Fire Marshal Division

**Re: Final Touch Powder Coating
2016 Ray Rd.
Spring Lake, NC 28390**

Application Number BCOM2011-0009

LIFE/SAFETY PLAN
1/4" = 1' - 0"

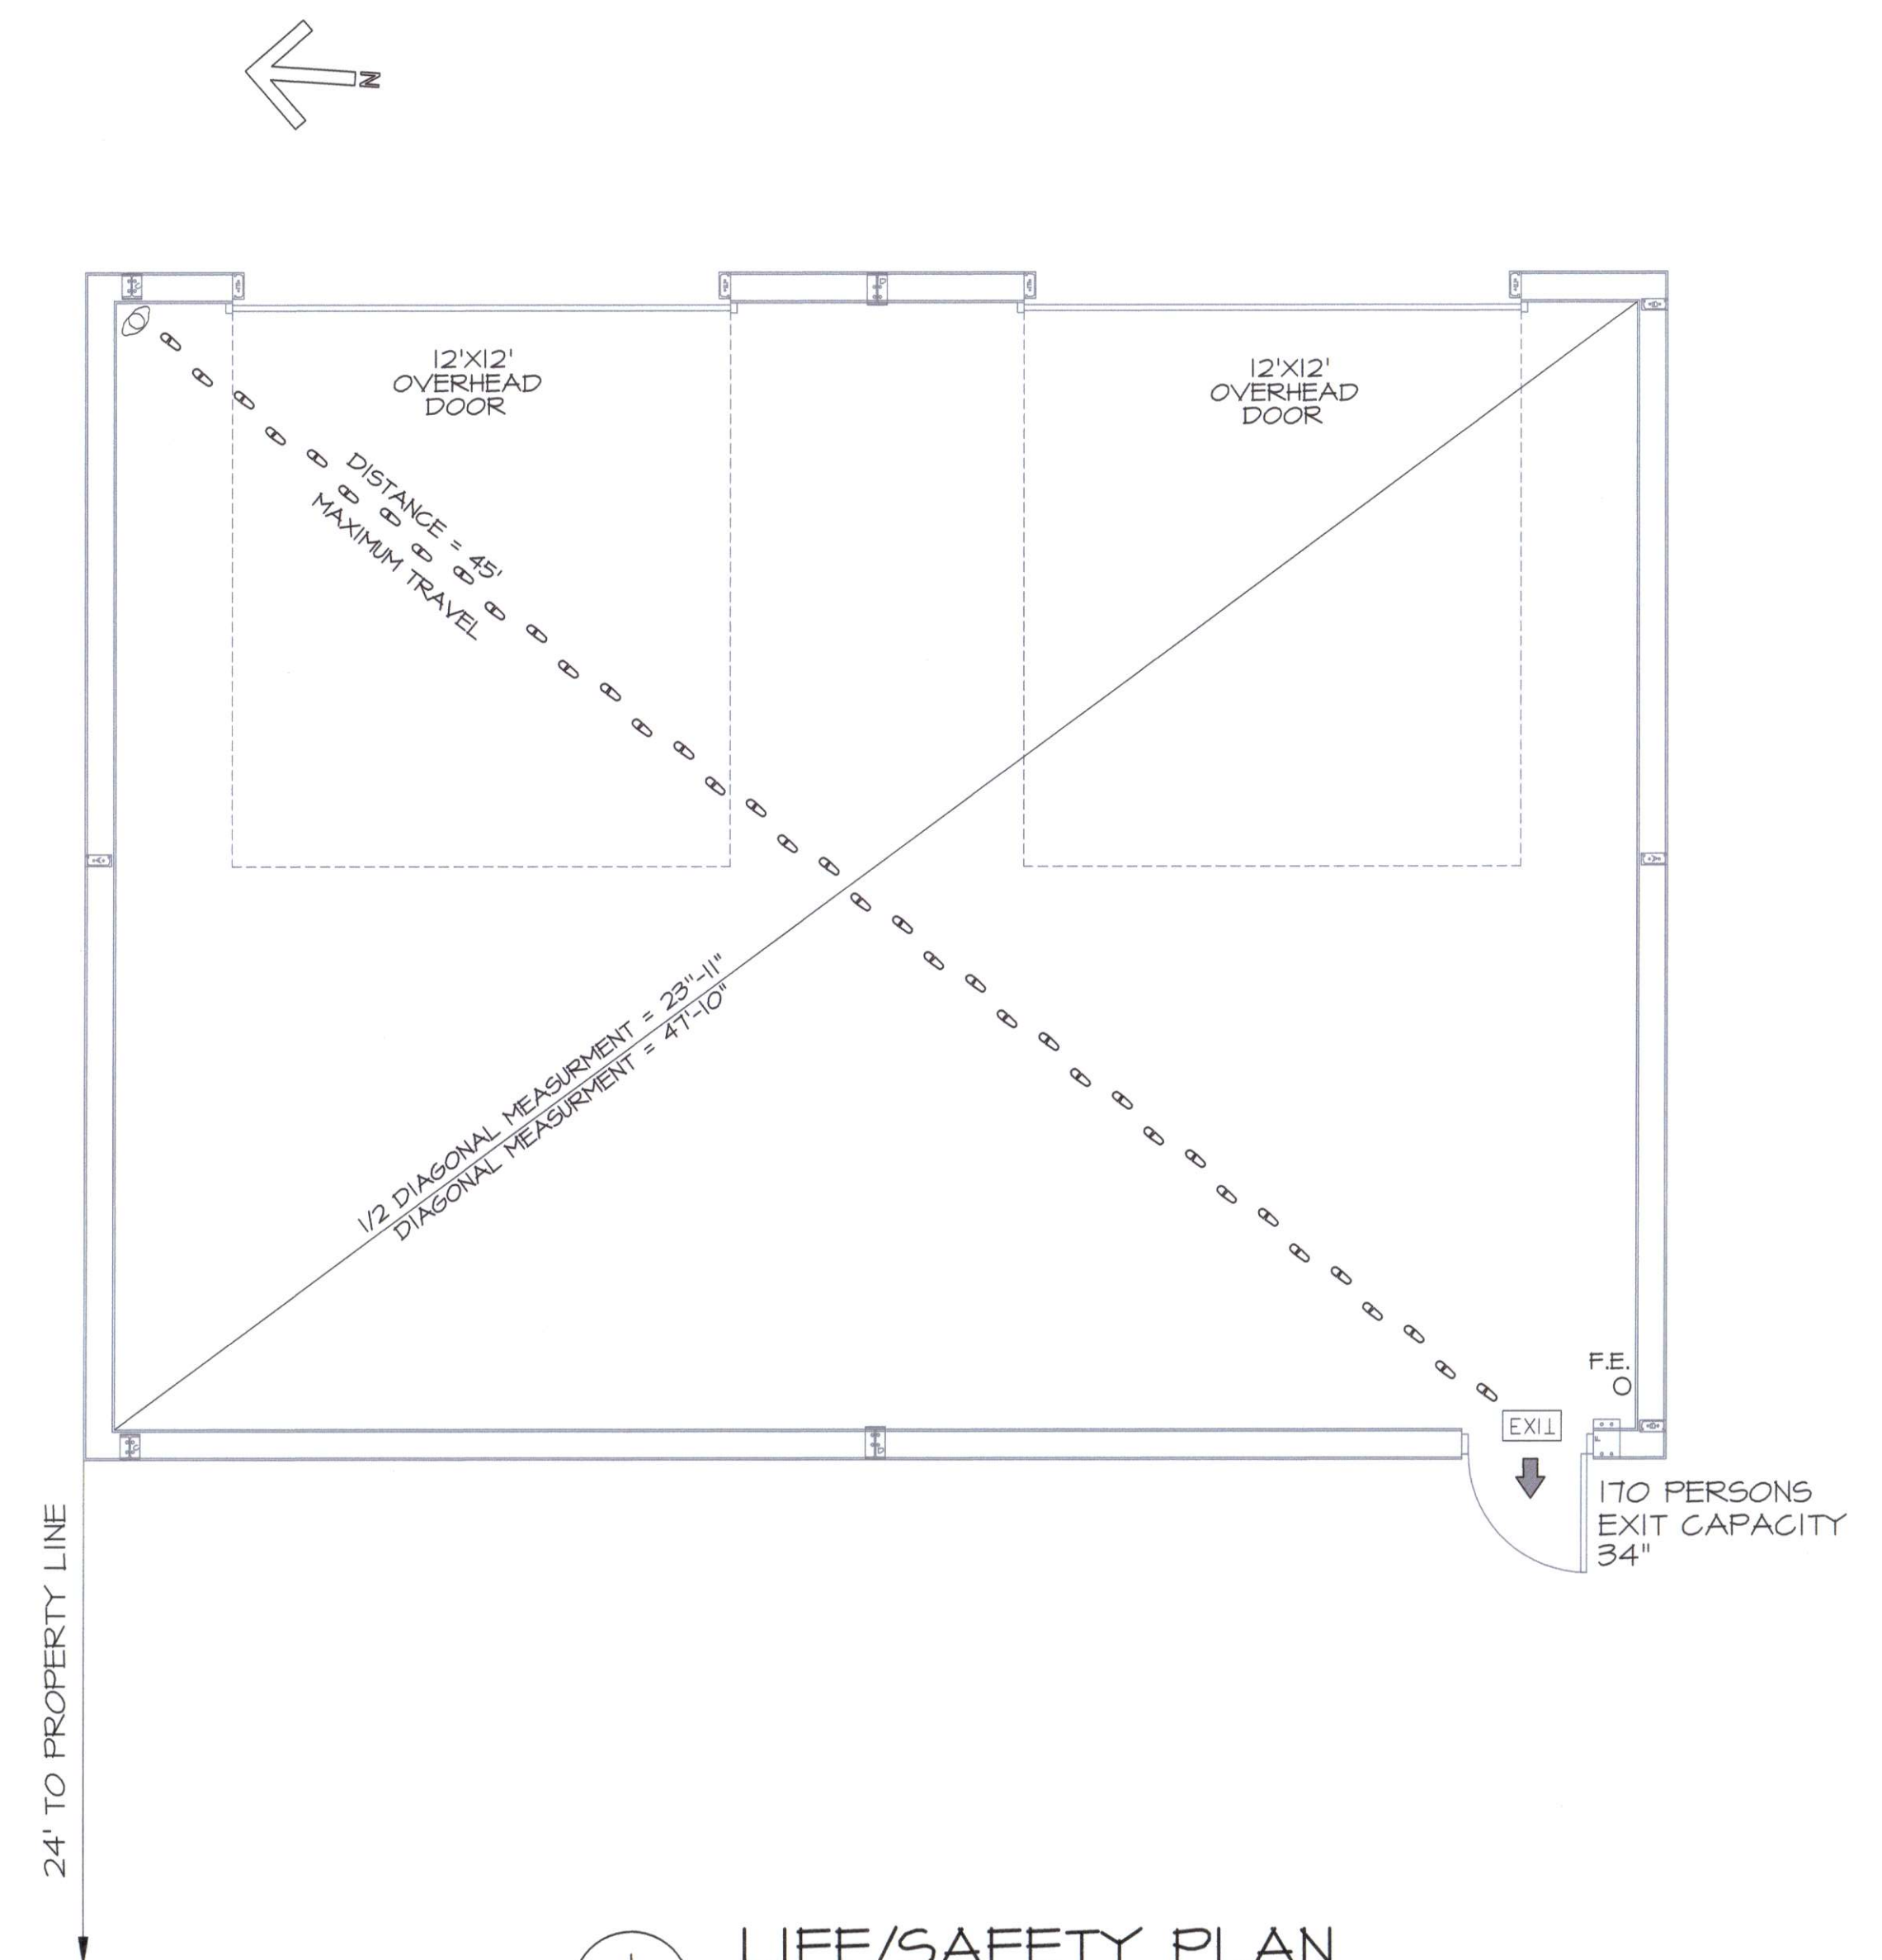
- **Fire Extinguishers**
 - Fire extinguishers shall be placed in approved locations and may be field verified on final inspection. The fire extinguishers provided shall have a minimum rating of 2A 10 B: C.
 - Fire extinguisher shall be installed not to exceed 75' distance of travel.

- **Emergency Illumination**
 - Emergency illumination is required to meet minimum foot candle illumination for all portions of the means of egress, including the exit discharge.

- **Exit Signs**
 - Exit signs shall be installed at all required exits. Exit signs shall meet all provisions of chapter 10.

1
M1 HVAC PLAN
 1/4"=1'-0"

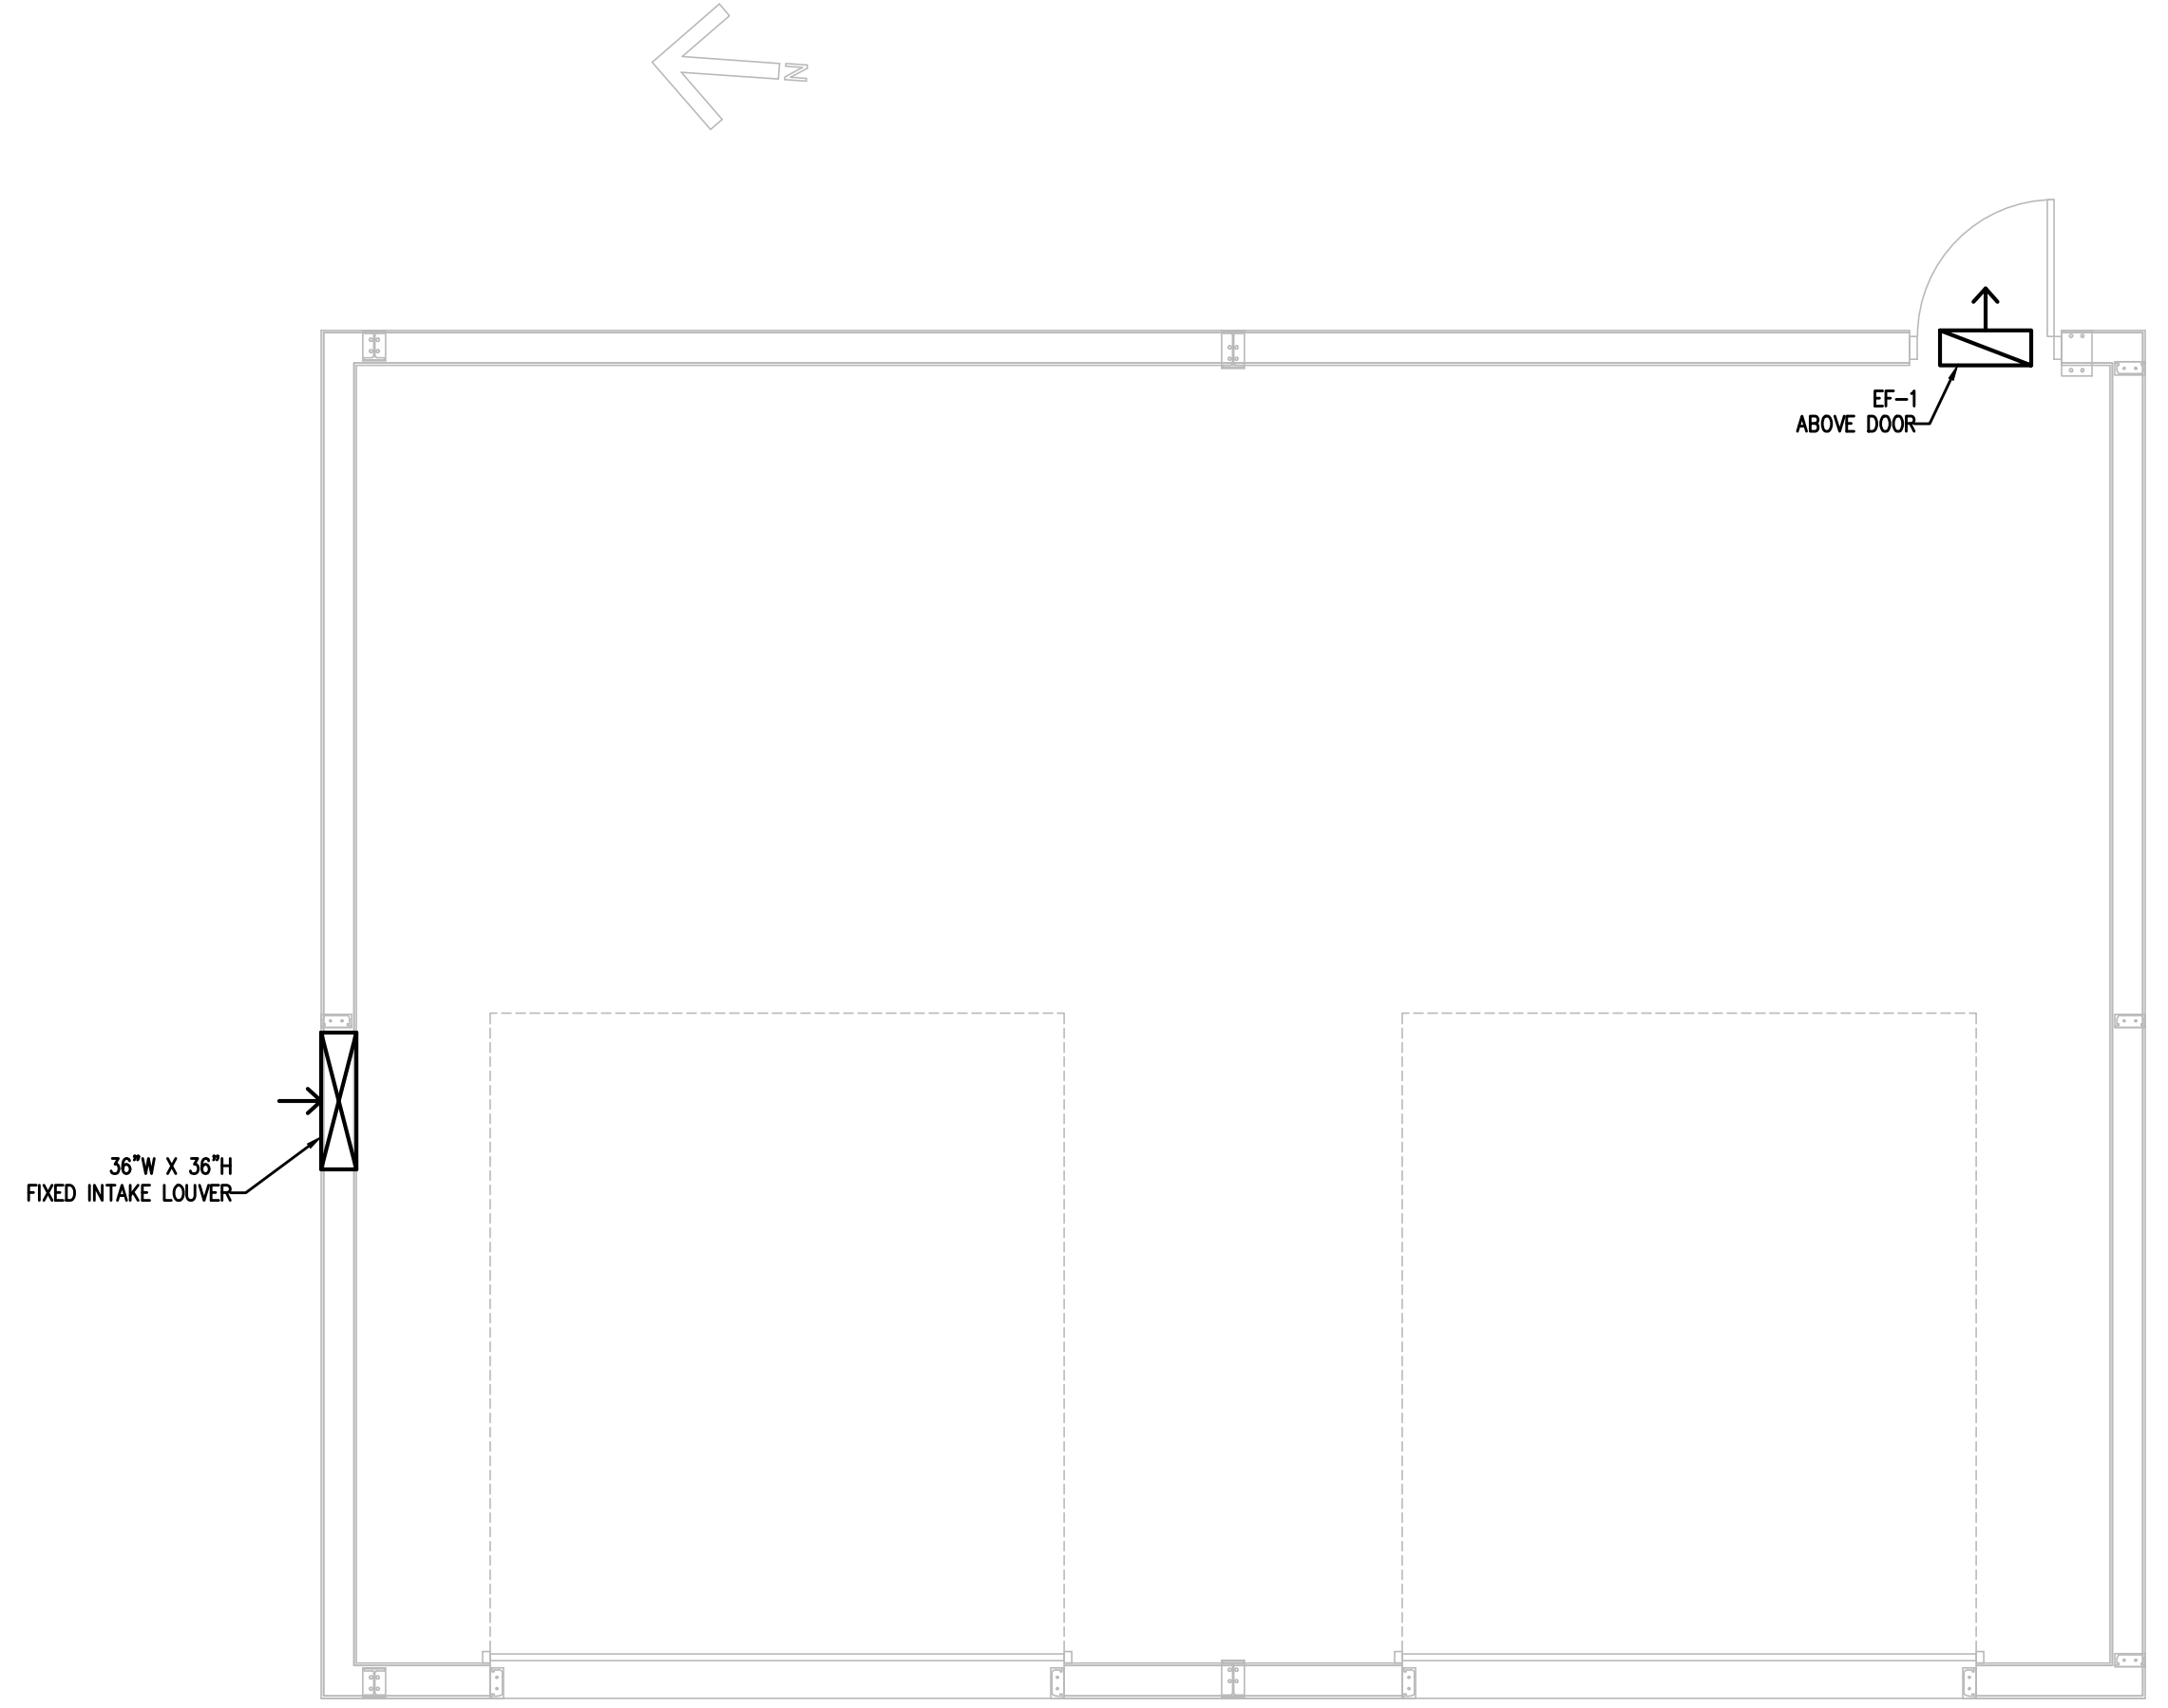
- **Duct Smoke detectors.**
 - Smoke detectors installed in ducts shall be listed for the air velocity, temperature and humidity present in the duct. Duct smoke detectors shall be connected to the building's fire alarm control unit when a fire alarm system is required by Section 907.2. Activation of a duct smoke detector shall initiate a visible and audible supervisory signal at a constantly attended location and shall perform the intended fire safety function in accordance with this code and the International Mechanical Code. Duct smoke detectors shall not be used as a substitute for required open area detection.
